**KIRKLEES METROPOLITAN COUNCIL  
INVESTMENT & REGENERATION SERVICE**

Reference No:	<b>2024/70/91601/E</b>
Site Address:	Land At, 14, Bracken Hill, Mirfield, WF14 0EZ
Description:	Variation of condition 2. (plans) on previous reserved matters application pursuant to reserved matters 2022/92259 for erection of residential development (one dwelling)
Recommending Officer:	Edward Cheseldine

## **Officer Report**

2024/91601 - Land At, 14, Bracken Hill, Mirfield, WF14 0EZ

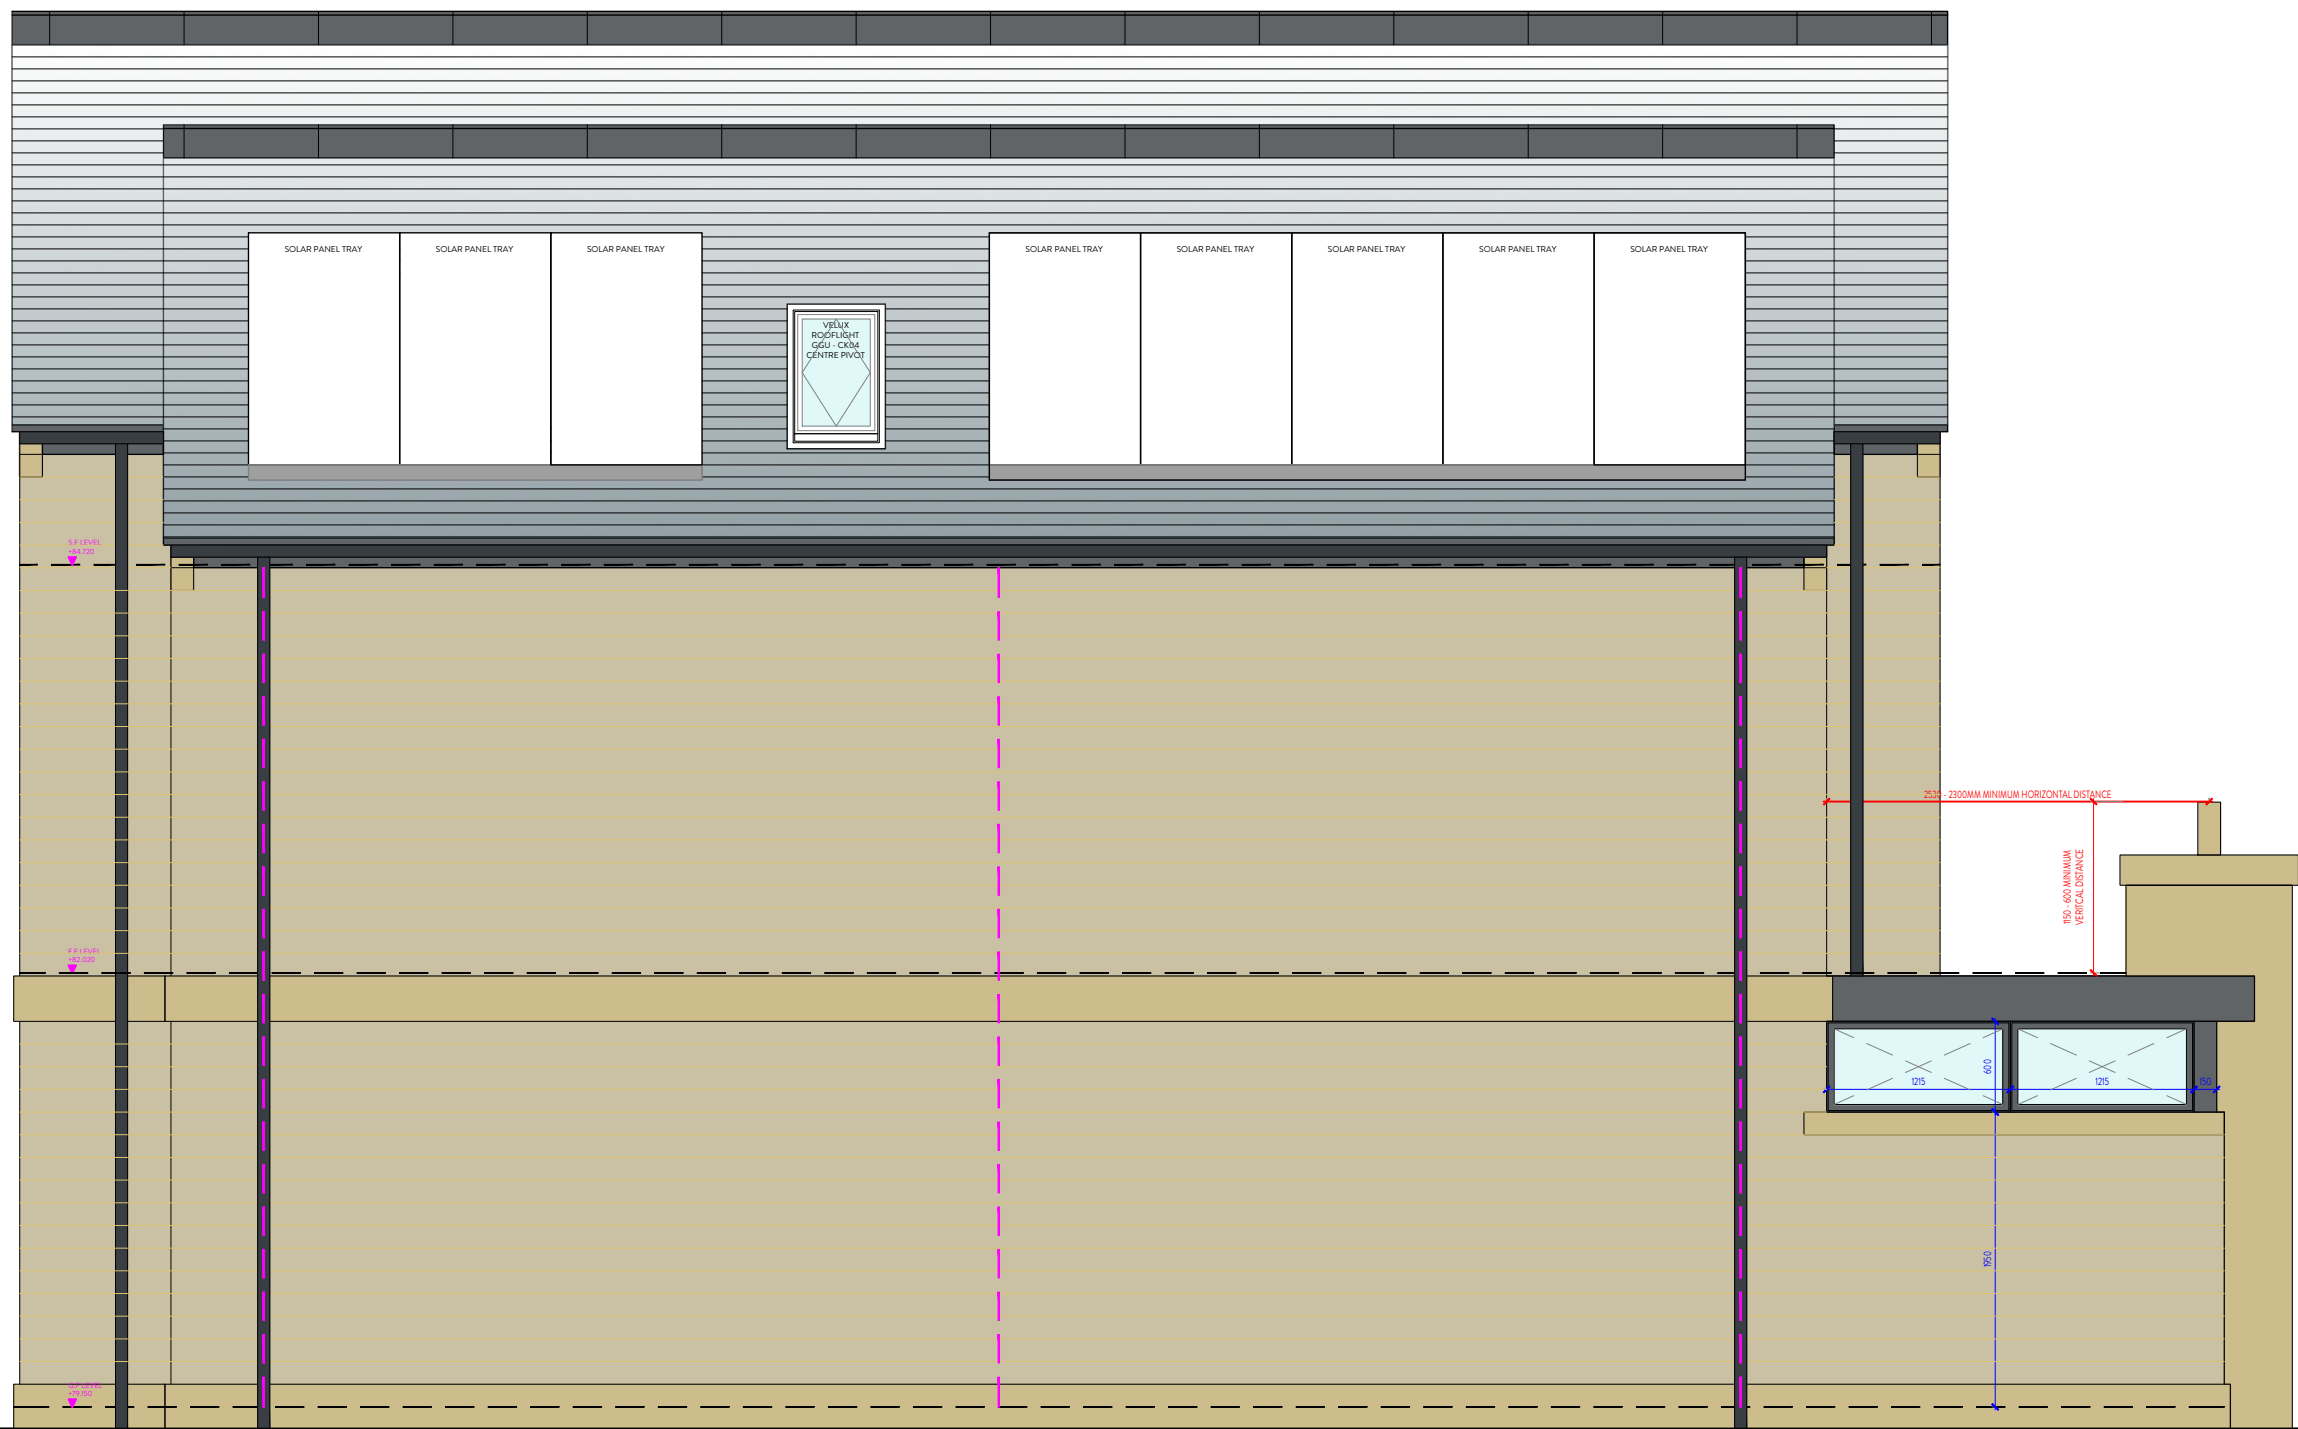
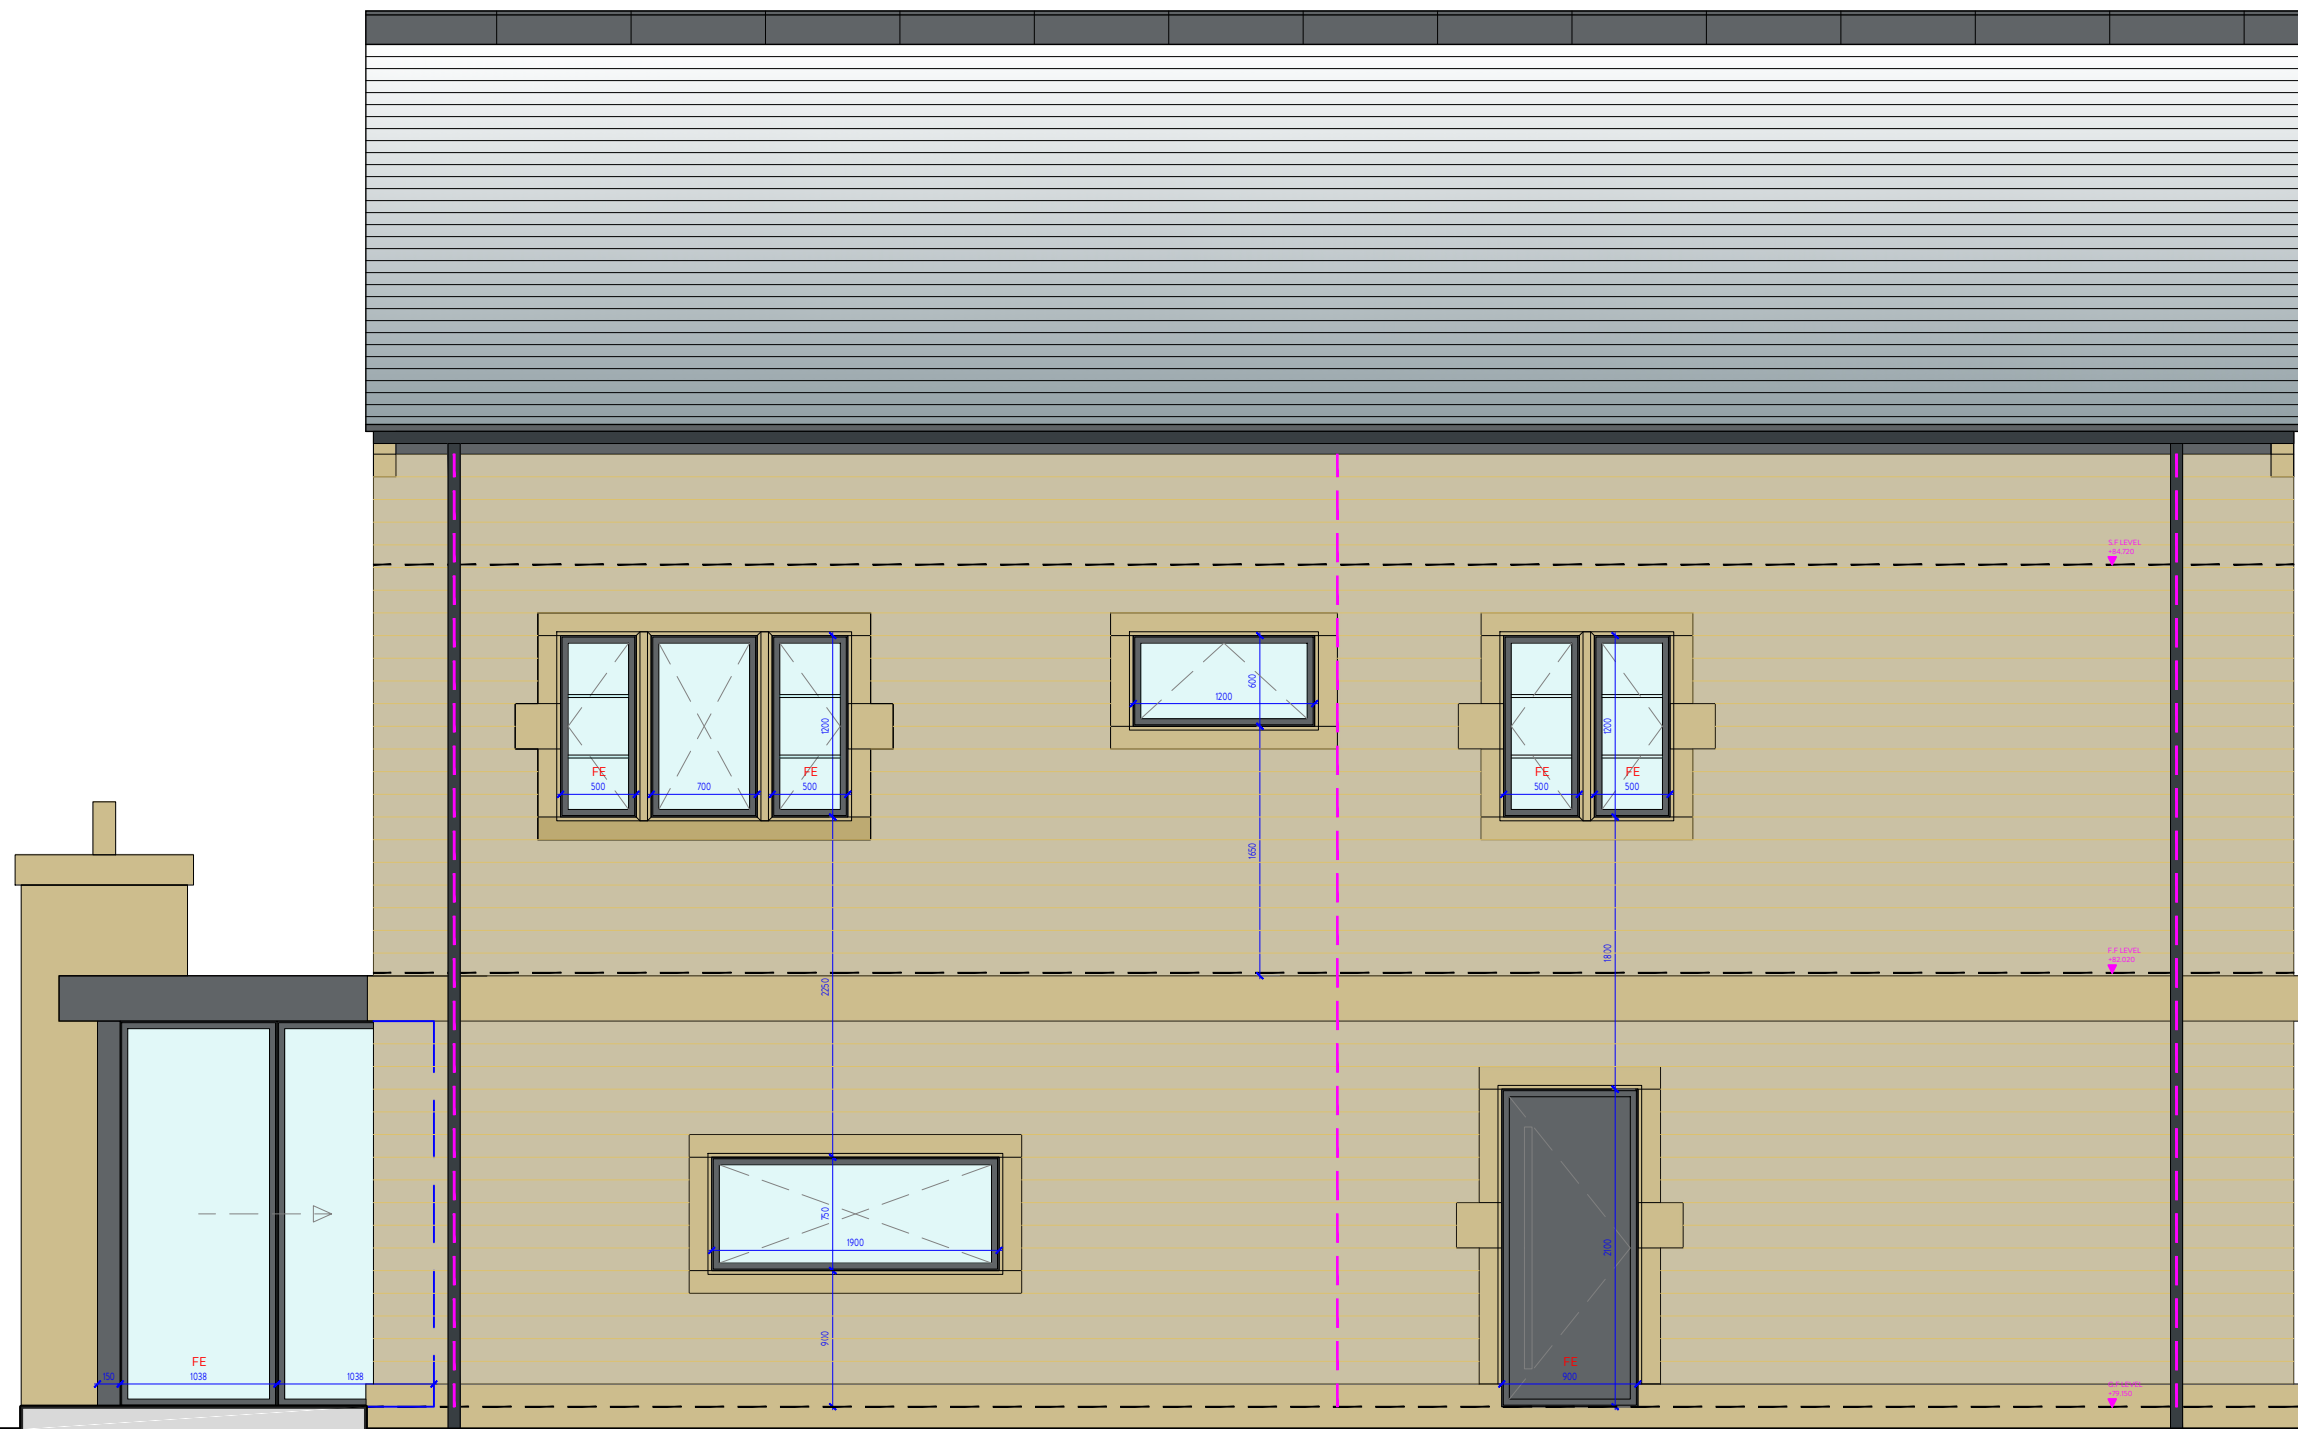
- Removal of stone quoin details
- Addition of coping stones
- Addition of 2 solar panels on front roof plane
- Alteration of glazing on the central column of the front façade
- Rear stone details added
- Side 8 solar panels, 1 rooflight, change of window type on flat roof
- Adjustments to garage openings

In terms of the alterations, the variation proposes to remove the corbel features, although it is considered that the traditional appearance of the dwelling is formed through its architectural design and wall materials. Stone coping will be added to redress their removal. The removal of glazing on the front façade is minor and mullion features will be added. These details are considered to respect the appearance of the neighbouring dwellings and are sympathetic to the wider area.

Solar panels are proposed to be introduced being placed on the front elevation and south-east side elevation. These solar panels will be positioned within the confines of the roofspace in a linear layout. Whilst they will be visible from the public domain, they do not appear incongruous and respect the appearance of the property which is set back from the roadside. The addition of the solar panels is therefore acceptable.

LP24 c), which sets out that proposals should promote good design by, amongst other things, extensions minimising impact on residential amenity of future and neighbouring occupiers. There is the inclusion of a rooflight that serves a dressing room. The opening is formed on the roof plane and as such does not have a direct relationship with any adjacent dwelling. It is not considered the new window will have an impact to privacy. All other changes to openings are changes to previously assessed openings in terms of their impact to privacy.

The proposed design variations accord with Policy LP24 of the Kirklees Local Plan, as well as Principle 2 & 12 of the Kirklees Housebuilders Design Guide SPD.

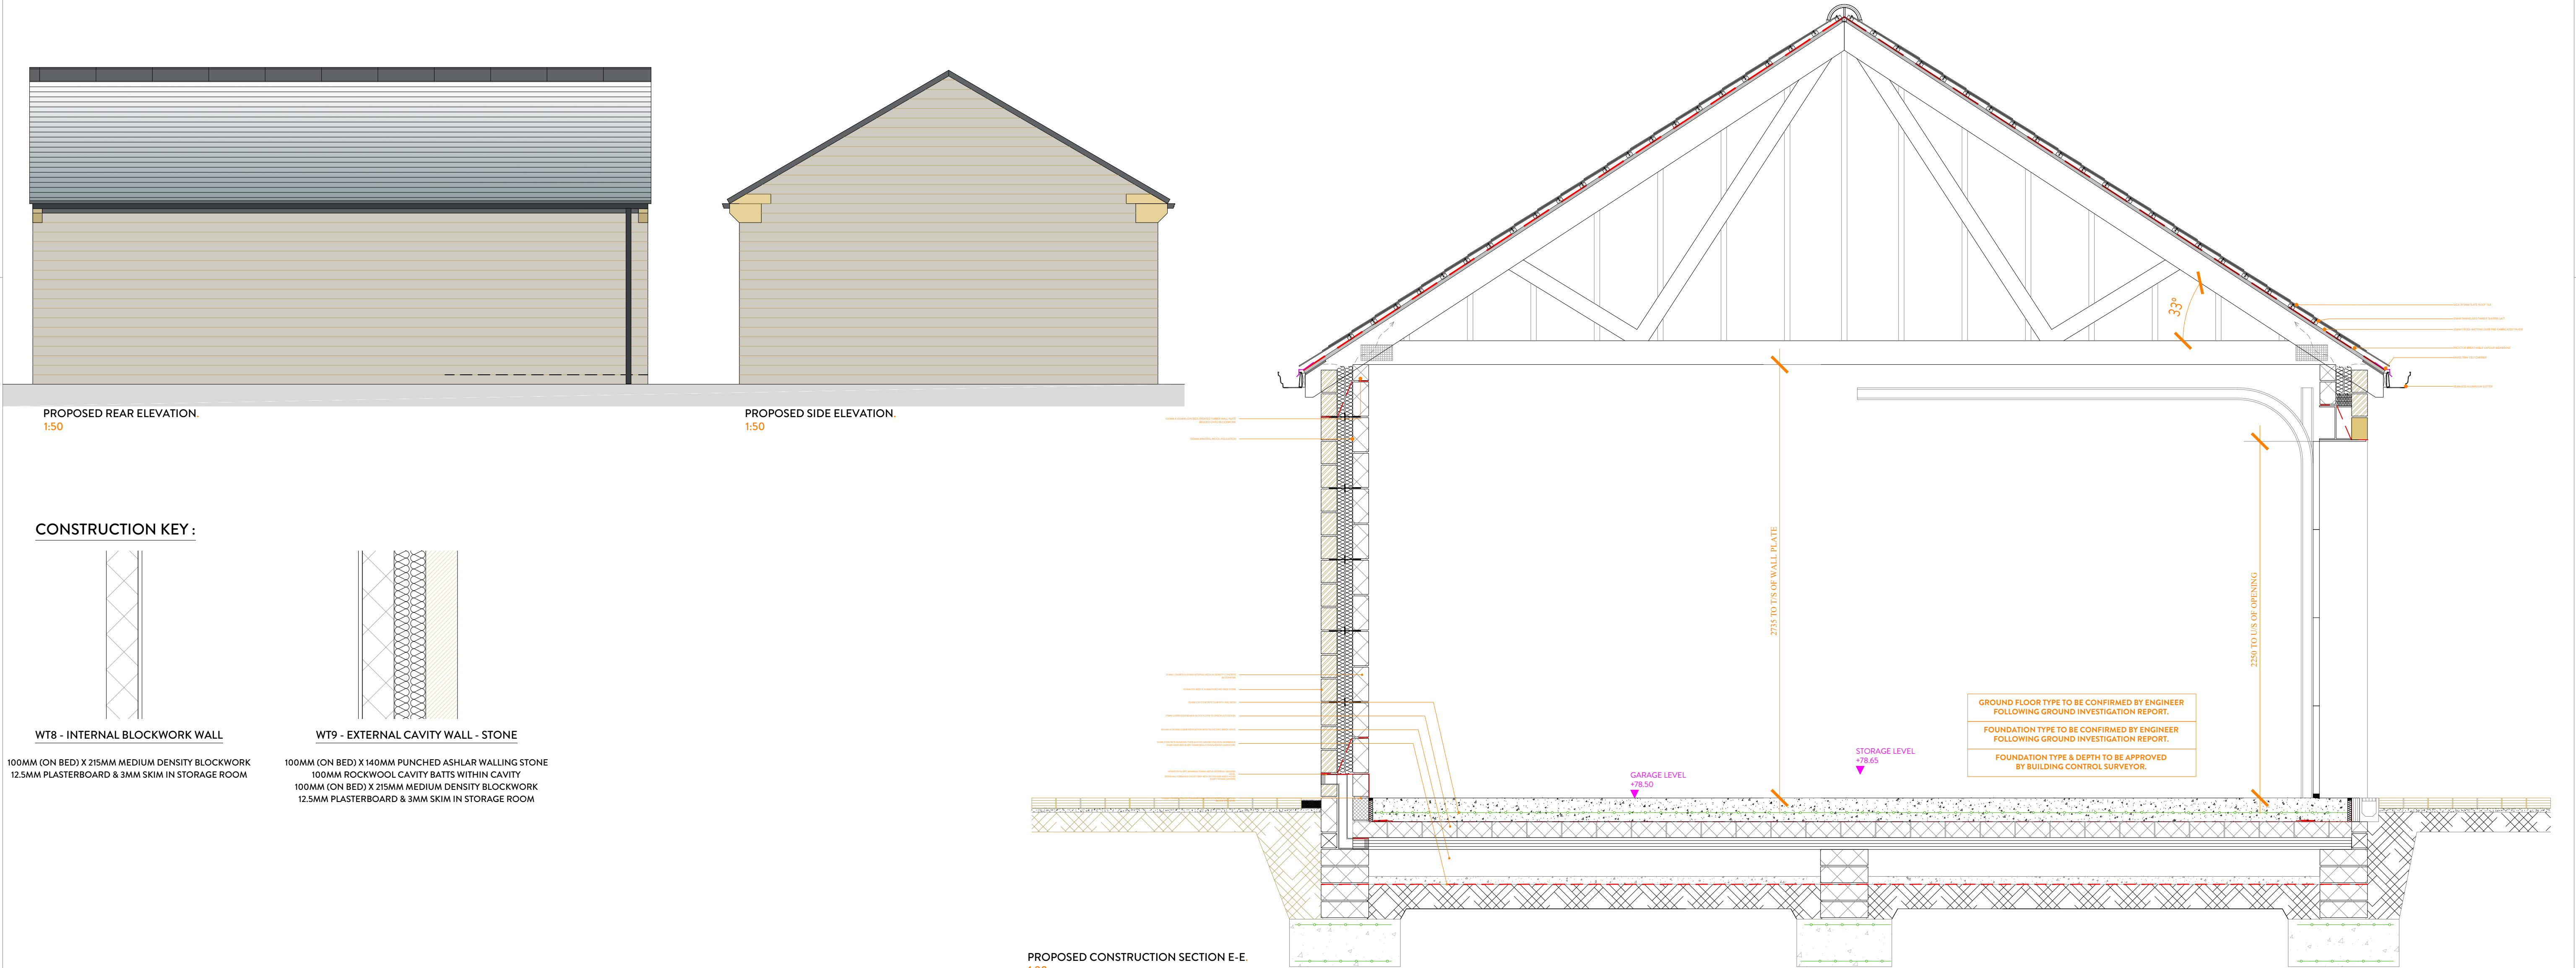
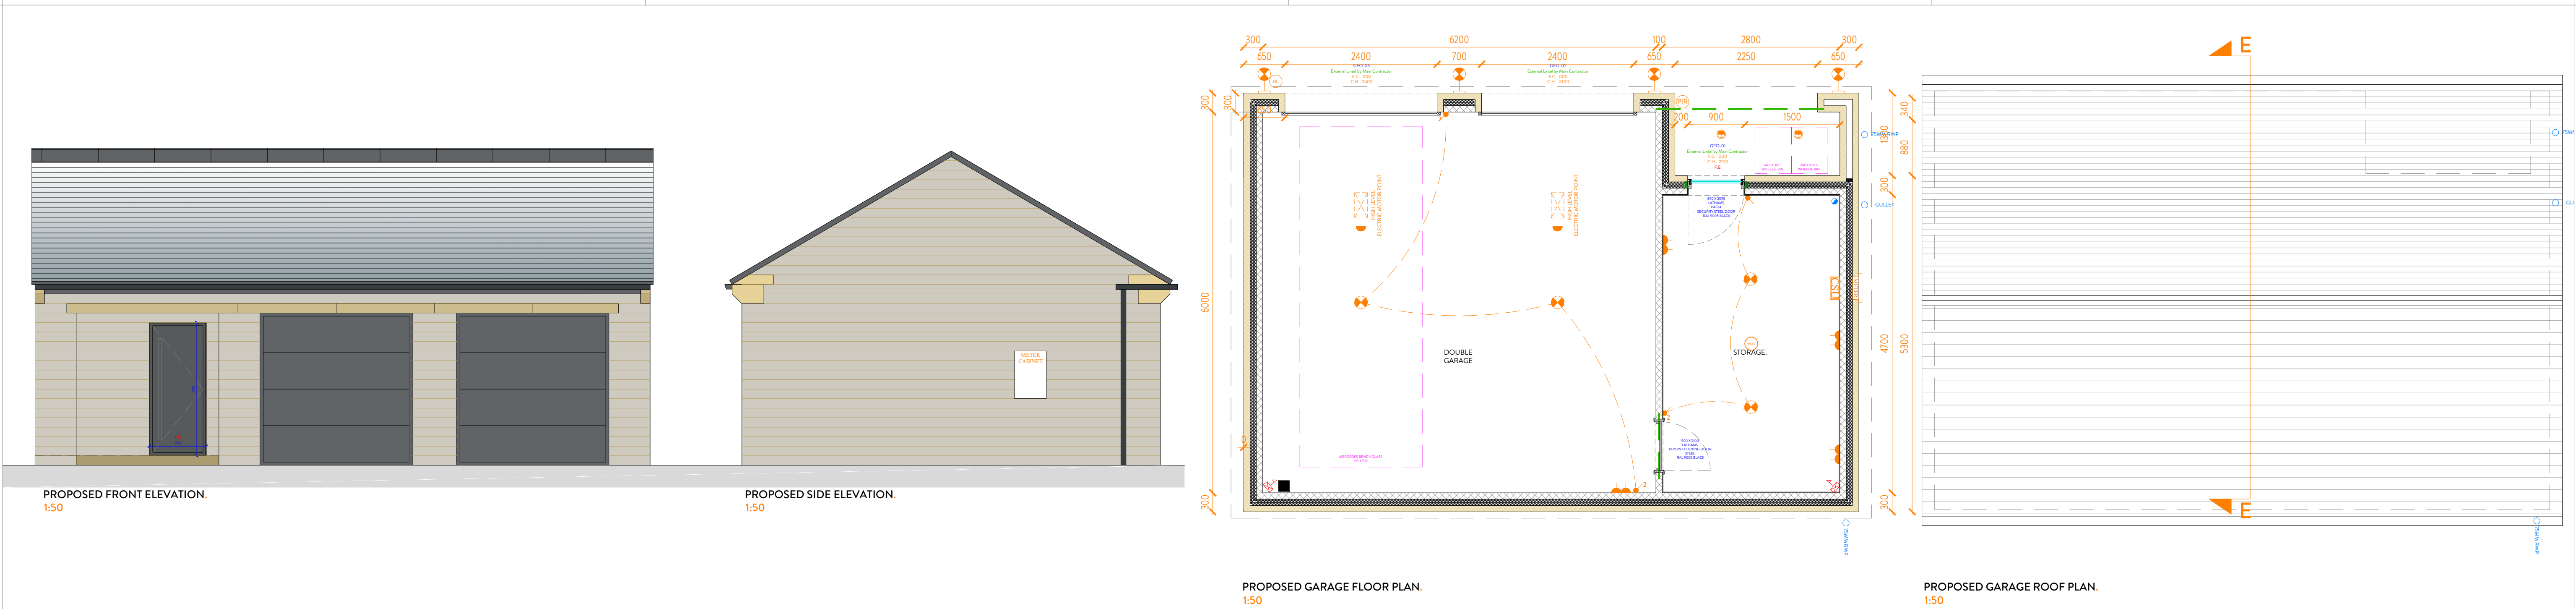
There will be limited alterations to the detached garage, changing the 3 garage doors to 2 single garage entrances and 1 door. The massing and height of the garage will not change, with the changed being minor and therefore acceptable.
